## Department of Primary Industries

OUT16/49093

### **Frazer Park Quarry Resource Recovery Facility (SSD 6518) Comment on the Environmental Impact Statement**

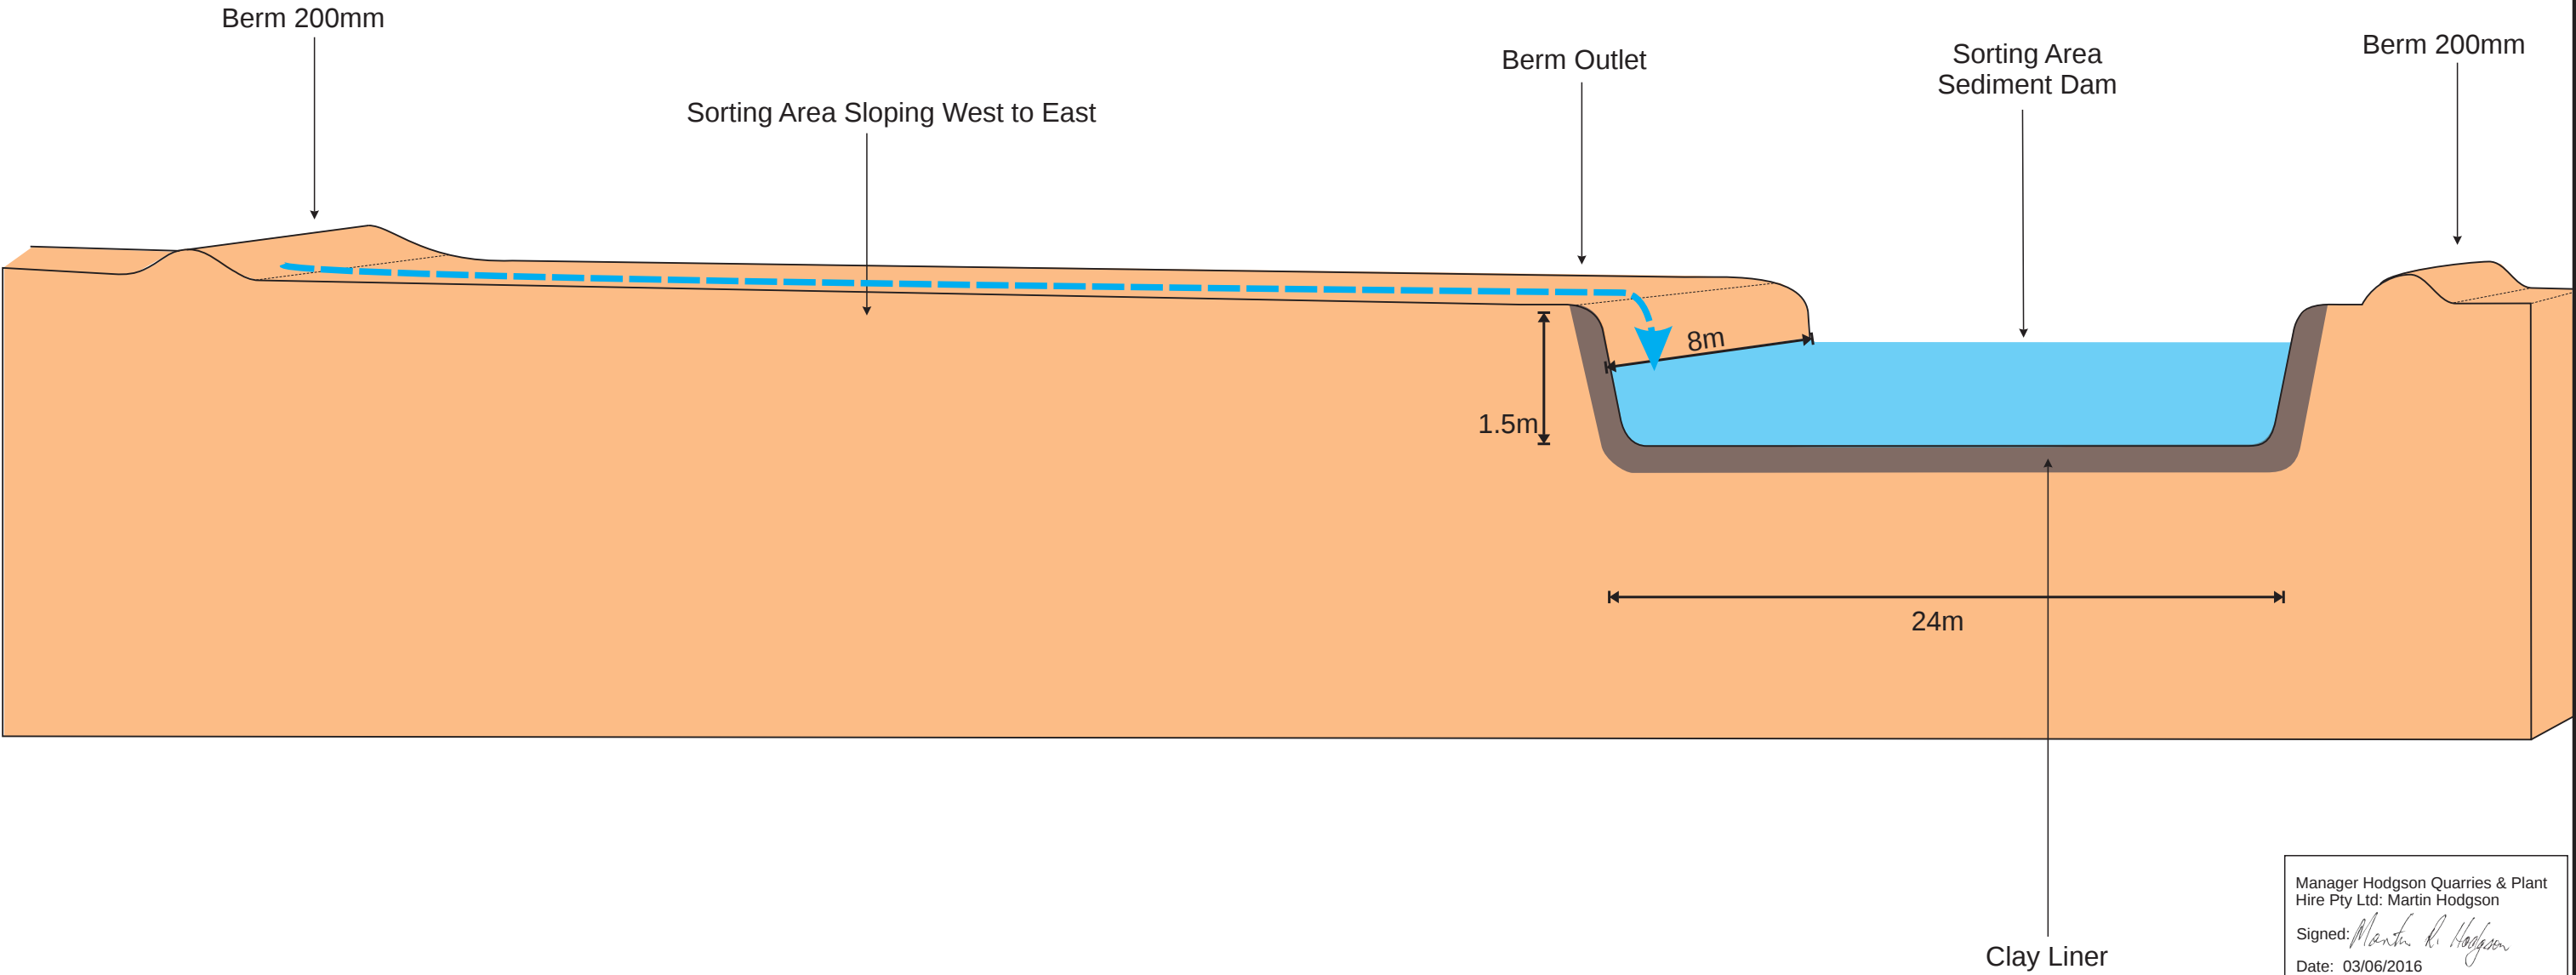
- Proponent to install liners to mitigate impacts to groundwater at the “Tip and Sort Area” and downstream dams that may potentially receive contaminated water.
